HILLSIDE EAST

CHARLOTTE-MECKLENBURG PLANNING COMMISSION
 INTER-OFFICE COMMUNICATION

DATE: December 4, 1997
 FROM: *mcc* (cc) Martin R. Cranton, Jr. Planning Director
 TO: Robert Brandon Zoning Administrator
 SUBJECT: Administrative Approval for Petition No.96-35, Hillside East. The Boulevard Company. Tax Parcel No. 151-092-30.

HILLSIDE EAST

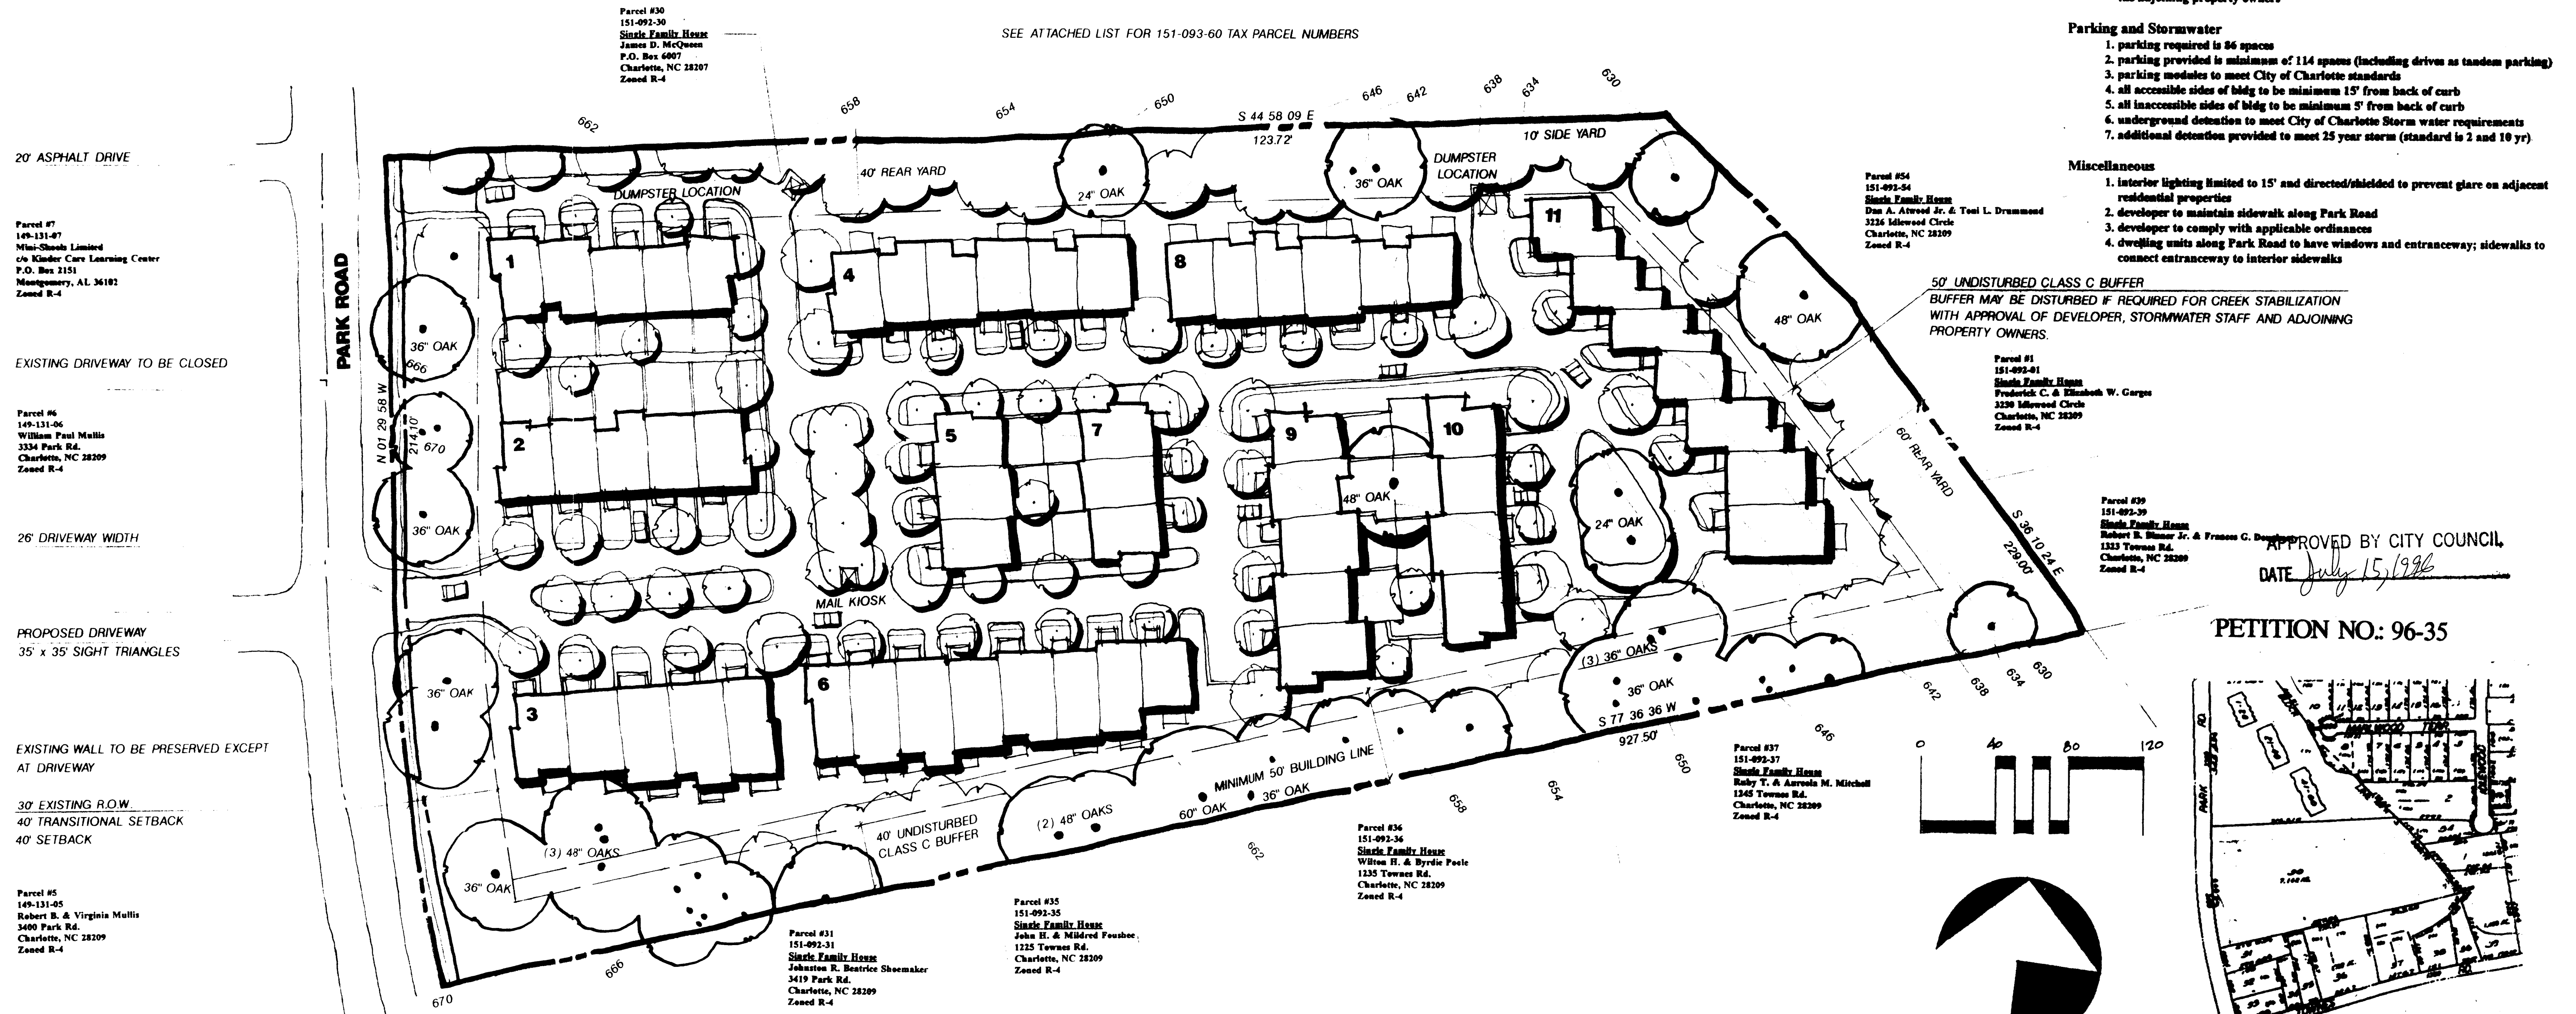
- 1.) The removal of 2 1/2 inch caliper maples in the cul de sac to the rear of the site. To create a better grade relationship these trees are to be removed and replaced with 4 1/2 inch caliper maples.

- 2.) The addition of a brick privacy wall to building #1 to give the property owner privacy in their rear yard.
- 3.) The revision of the requirement of dedication of 40 feet of right of way prior to the issuance of any building permits with reservation and dedication of up to 40 feet from centerline upon request by the City of Charlotte Department of Transportation. This revision is required to accommodate the location of a brick retaining wall out of the public right of way and to further protect existing trees to be saved in the setback.

- 4.) The acceptance of the storm water system as shown on the approved subdivision plans with the commitment by the developer to apply for storm water credits thereby committing to annual inspection and required maintenance as determined by the City of Charlotte engineering staff.

October 23, 1997
 Additional right-of-way to be dedicated 10' from back of curb before issuance of building permits. The owner(s) of the property will dedicate right-of-way shown on the plans (shown as reserved) to the Charlotte Department of Transportation up to a maximum of 40' from the centerline of Park Road in conformance with the conditional development notes. This note to also appear on all recorded plat

As part of the approval of the stormwater system as shown on the subdivision plan, the developer commits to applying for the stormwater credit program through the City of Charlotte Engineering Department. See attached letter.
